CITY OF ALBUQUERQUE

**Re: Brunacini Warehouse
Erosion and Sediment Control Plan
Engineer's Stamp Date 2-5-19 (J10E002G)**

ENGINEER'S SEAL	7601 LOS VOLCANES RD NW ALBUQUERQUE, NM 87121	DRAWN BY pm
	EROSION CONTROL PLAN	DATE 2-5-19
RONALD R. BOHANNAN P.E. #7866	 5571 MIDWAY PARK PL NE ALBUQUERQUE, NEW MEXICO 87109 (505) 858-3100 www.tierrawestllc.com	DRAWING 2018074-SWPPP
		SHEET # SW-1
		JOB # 2018074

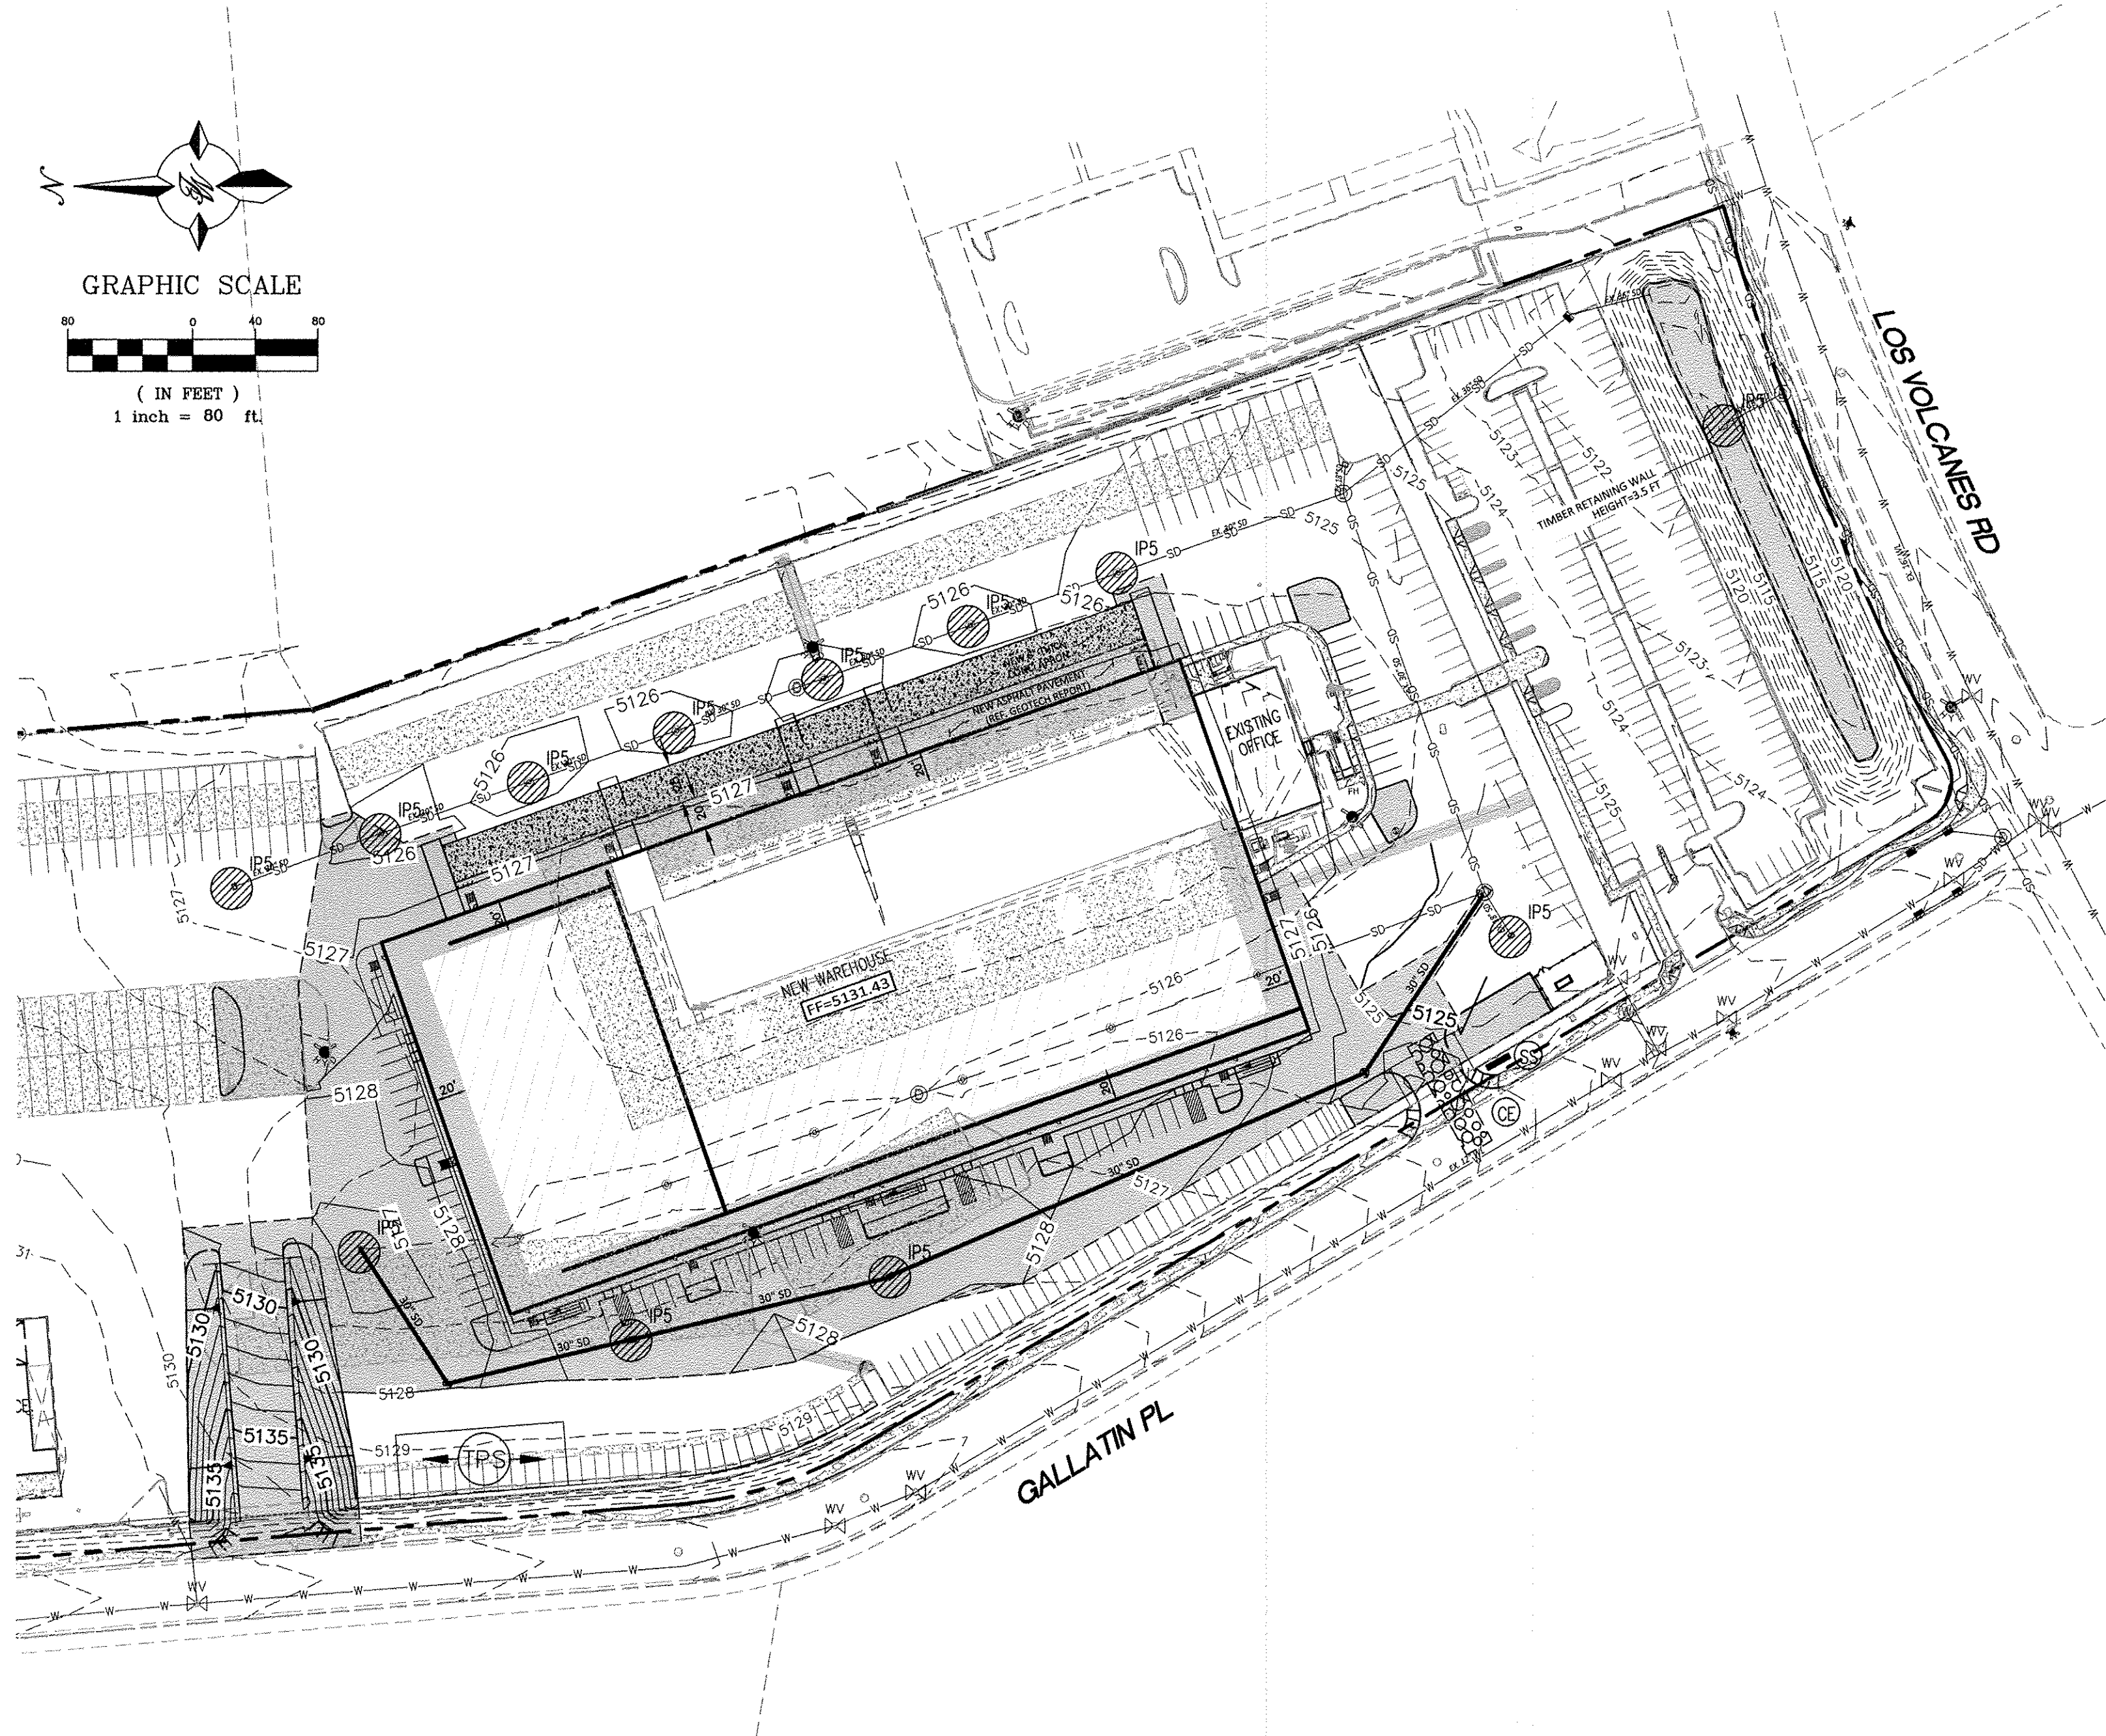
A sediment BMP may be required at the entrance(s) on Gallatin Pl where the proposed disturbed area is near/at the street.
